From: Martyn White <Martyn.White@arun.gov.uk>
Sent: 18 November 2019 13:52
To: Planning.Responses <Planning.Responses@arun.gov.uk>
Subject: BR/272/19/PL

BR/272/19/PL

The application relates to the replacement of existing failed balcony slabs together with the railings on like for like basis, along with works of repair to a canopy roof. I also note that the existing slab is to be repaired in parts.

Parsons Son & Basley
Sussex Court, Park Rd., B. Regis
REMEDIAL WORKS TO BALCONIES

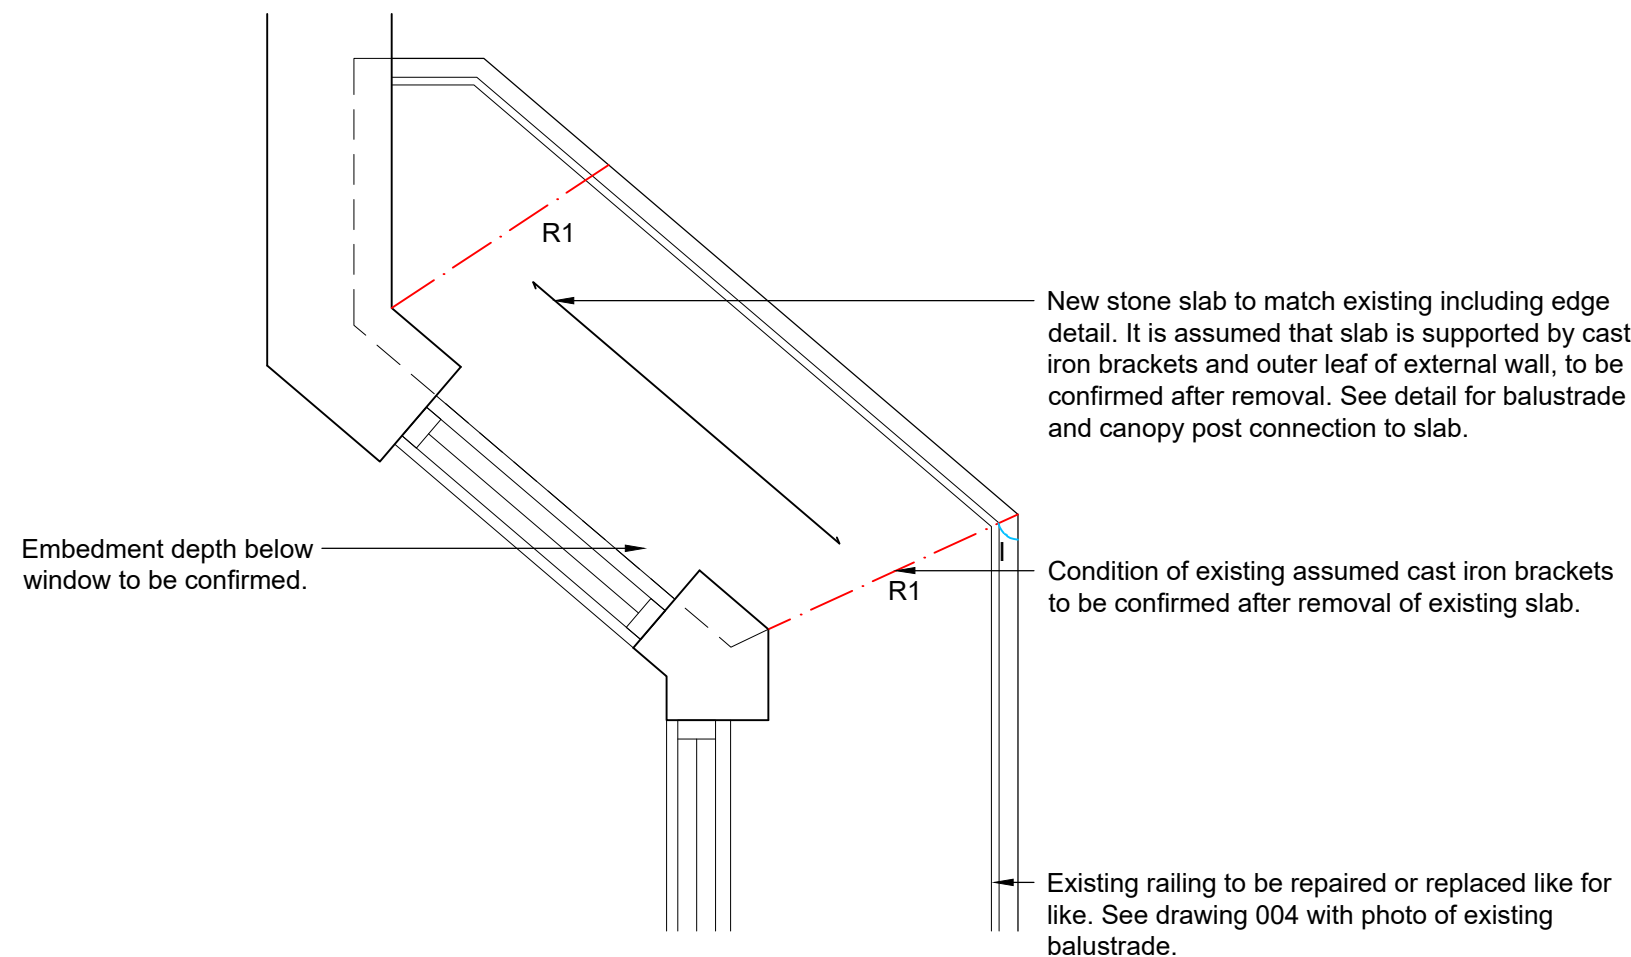
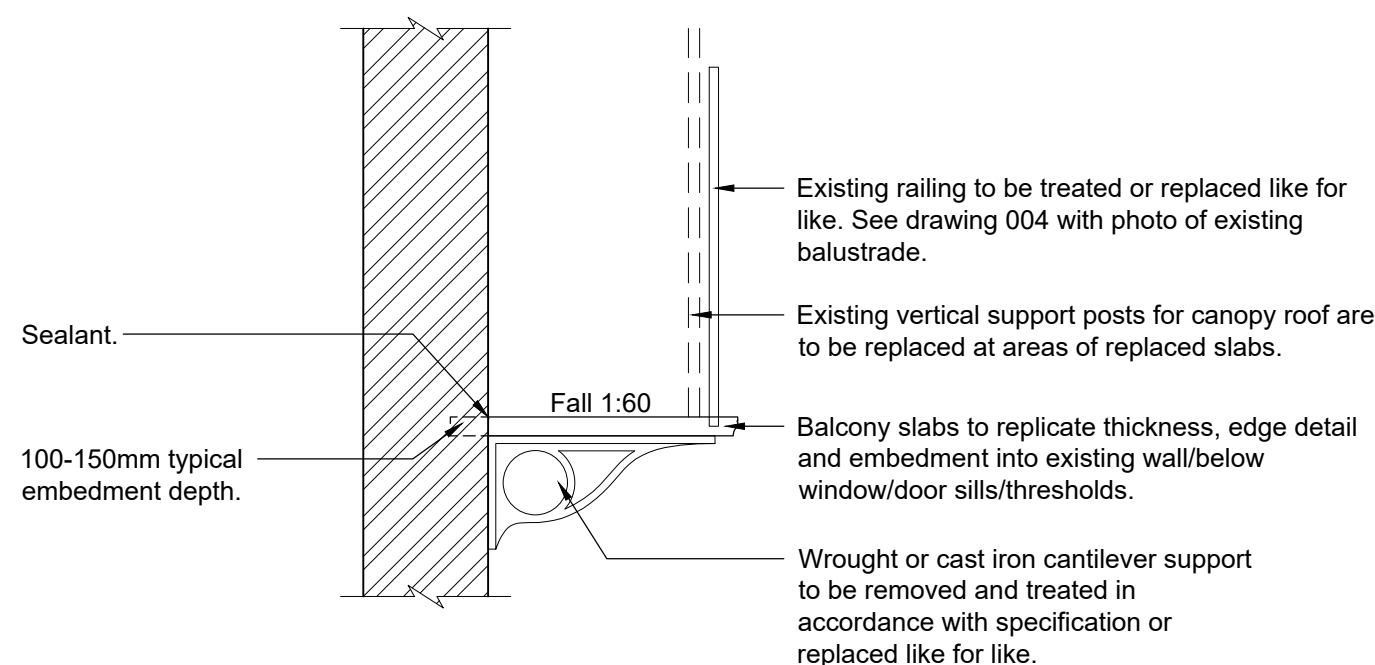
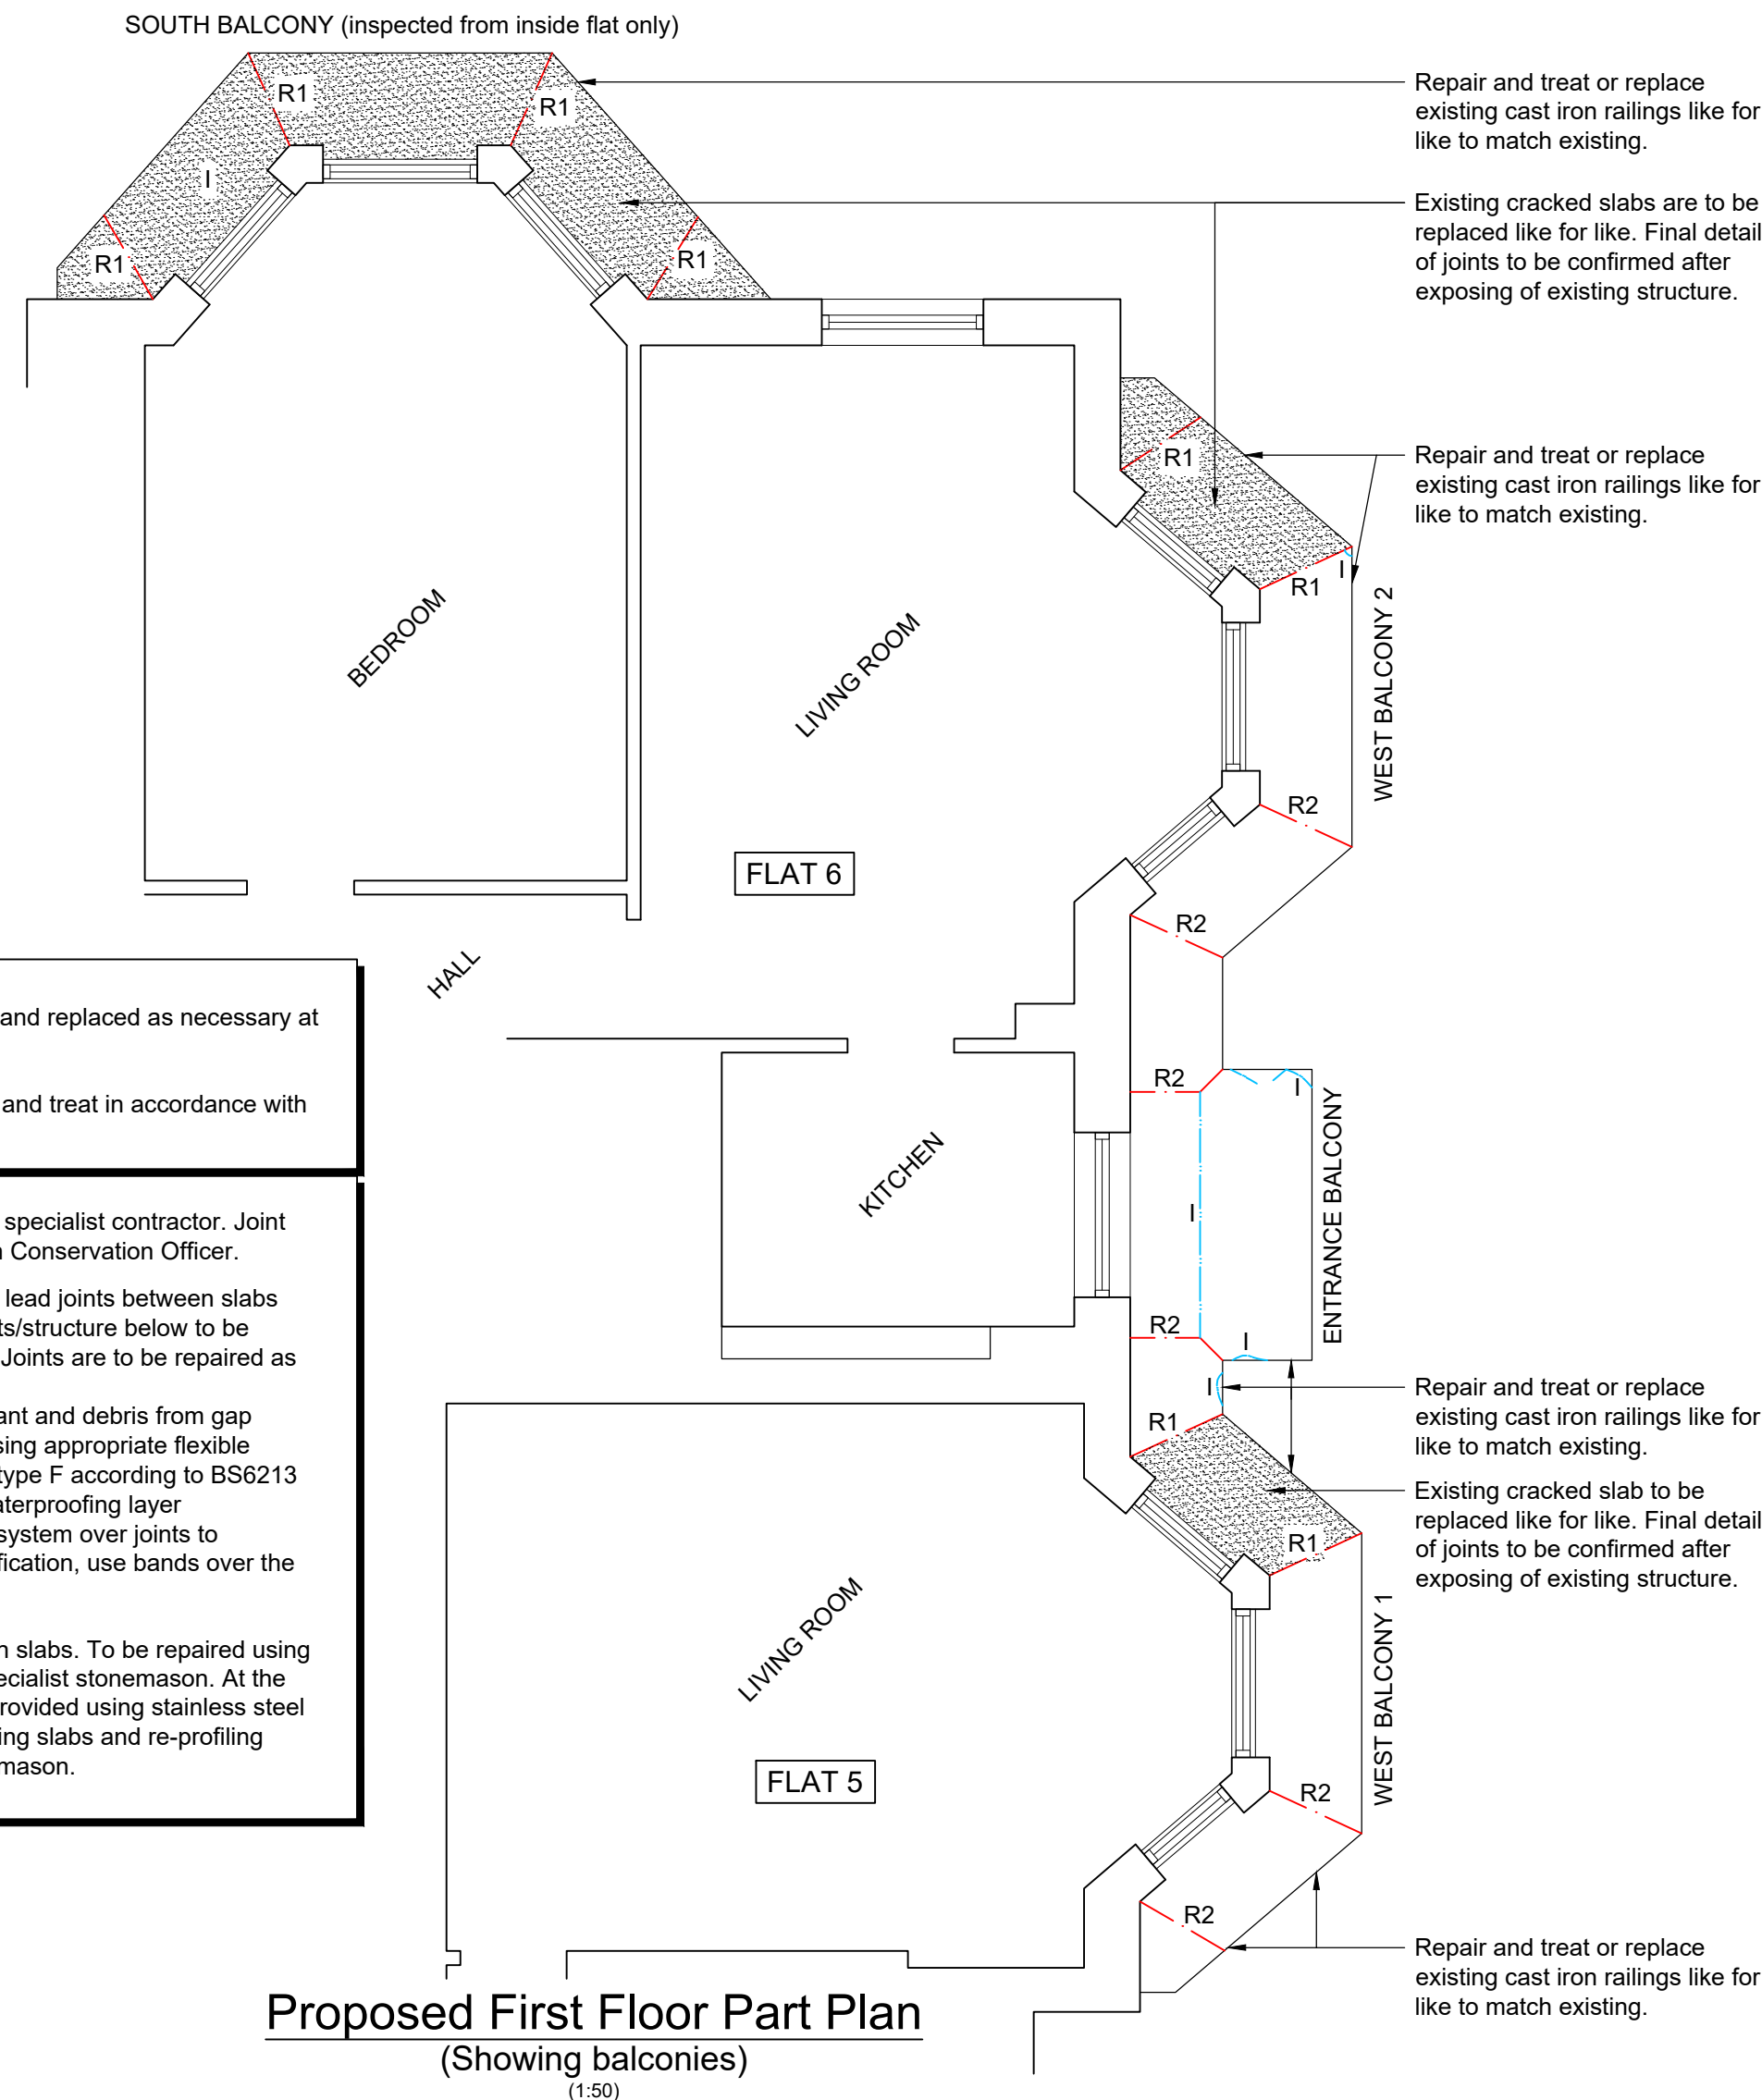
It is considered that the concept of undertaking works on either as repair or on a like for like basis is a positive one and can be supported. The concept of repair will ensure that the least amount of historic fabric is lost.

DETAIL OF RAILING

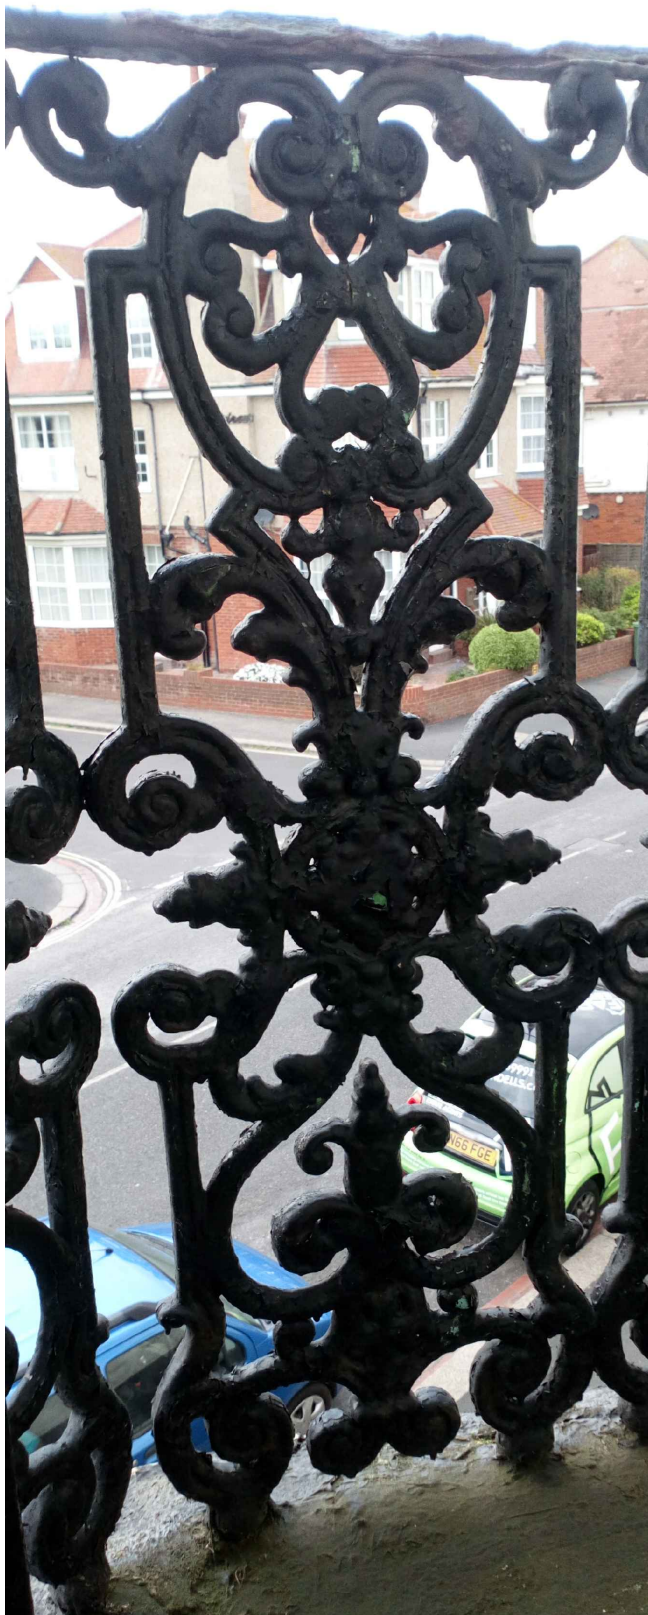
The railings and supports, if to be replaced, should match the existing ones in order to ensure that they reflect the character of the building. Any replacement materials should be treated in a manner appropriate to their historic context i.e. painted, as opposed to covered with a powder coating.
